01/04/2022

**Gunlake Quarry Continuation Project (SSD-12469087)  
Request for additional information**

I refer to the assessment for the Gunlake Quarry Continuation Project (SSD-12469087) (the project). The Department has carefully reviewed the Submissions Report and agency advice and requires the following additional information.

Gunlake Quarry Continuation Project
Groundwater assessment
Figure 6.4

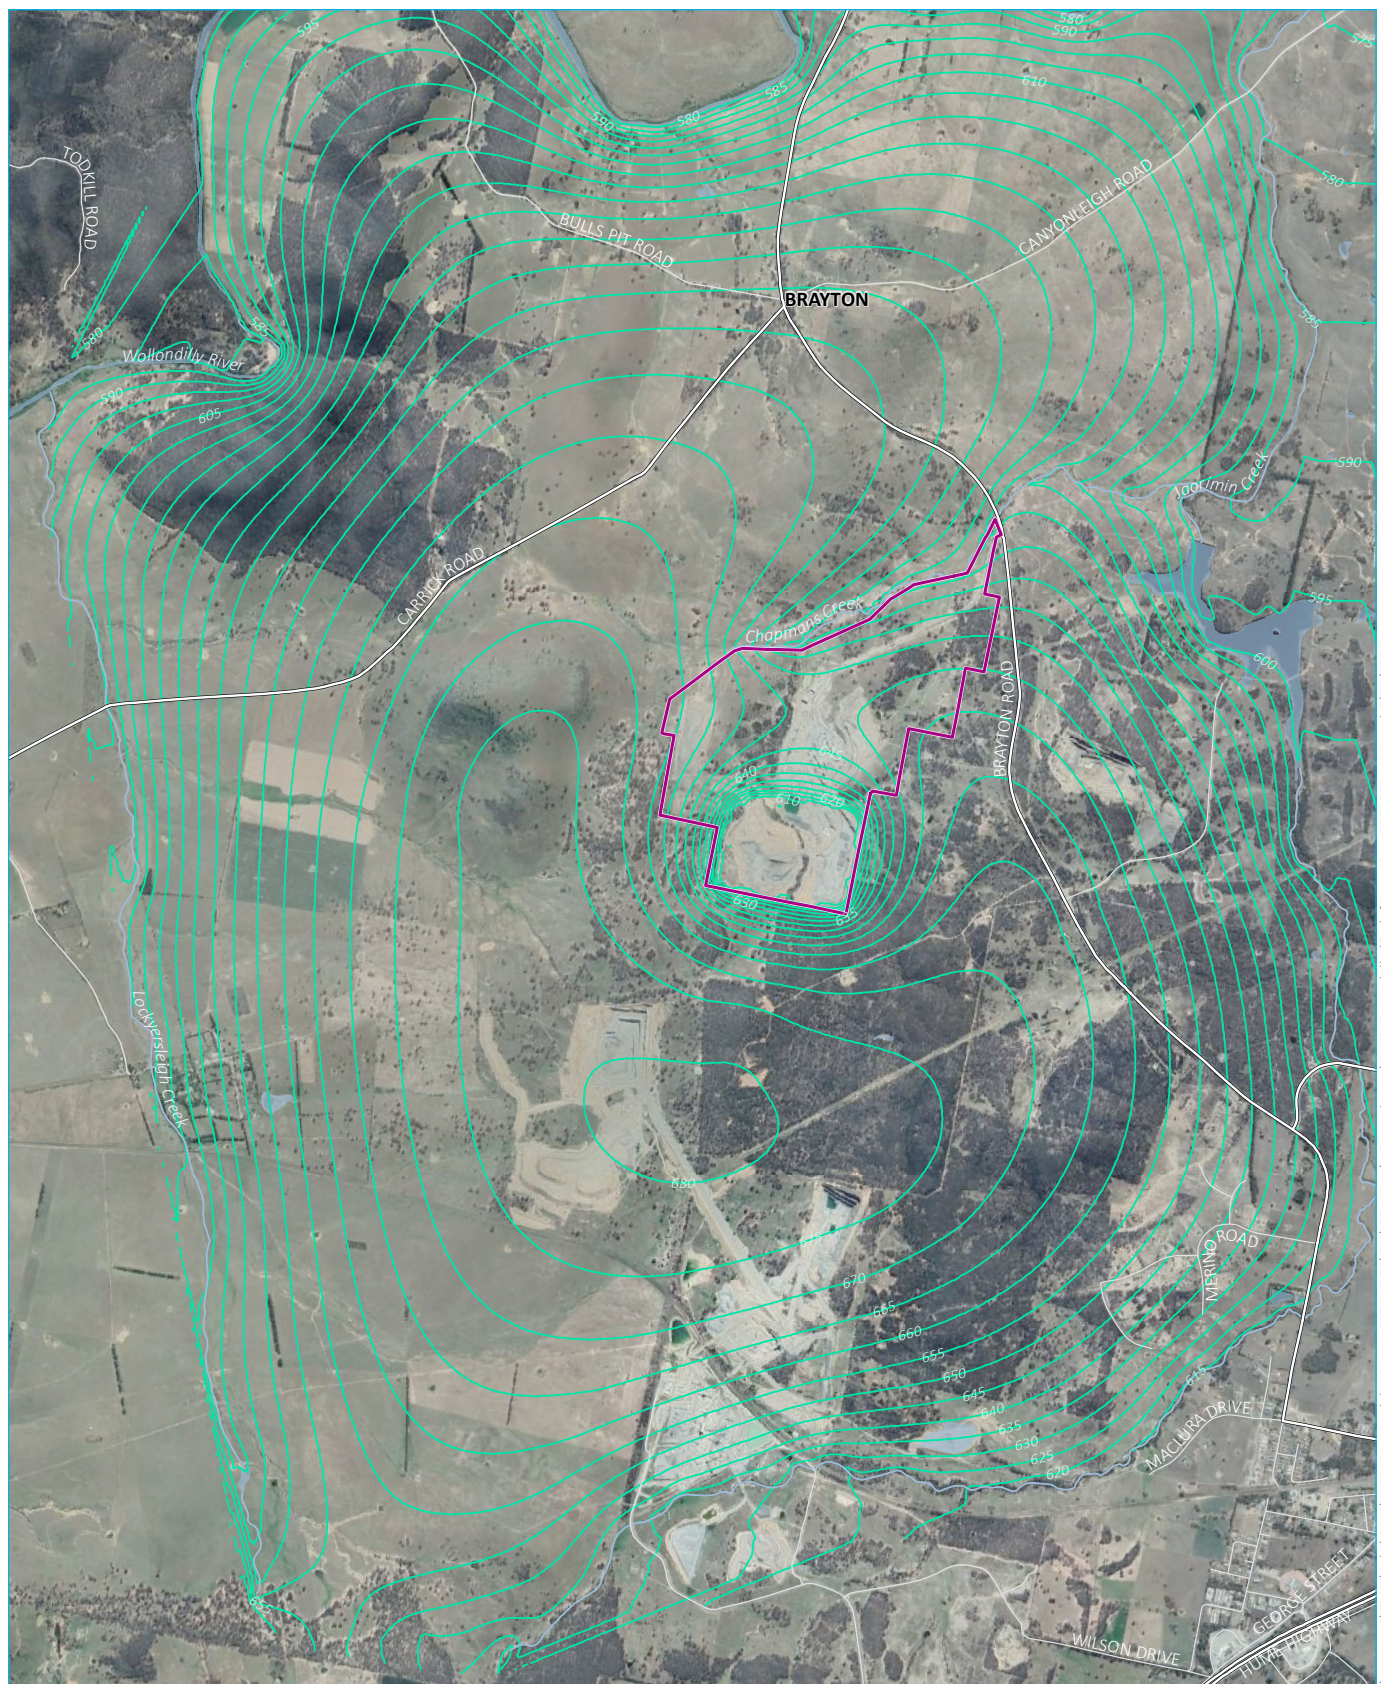
- Landowner's consent from Crown Lands for the paper roads, within adjoining Lot 13 DP 1123374 and the site boundary.
- Engagement outcomes with Goulburn Mulwaree Council regarding a Planning Agreement for the utilisation of local roads as the Primary and Secondary Transportation routes in the project.
- Digital shapefiles of spatial data used to prepare figures in the project's *Environment Impact Statement* (EIS), the Biodiversity Development Assessment Report (BDAR) and Groundwater Assessment:
  - Site boundary and project disturbance area (EIS Figure 3.1);
  - 'Area 1' (EIS Figure 3.1);
  - Vegetation mapping (BDAR Figure 6.2);
  - Biodiversity Assessment Method (BAM) plot location; and
  - Modelled groundwater drawdown (Groundwater Assessment Figures 6.4 to 6.6 and Figure 7.2).
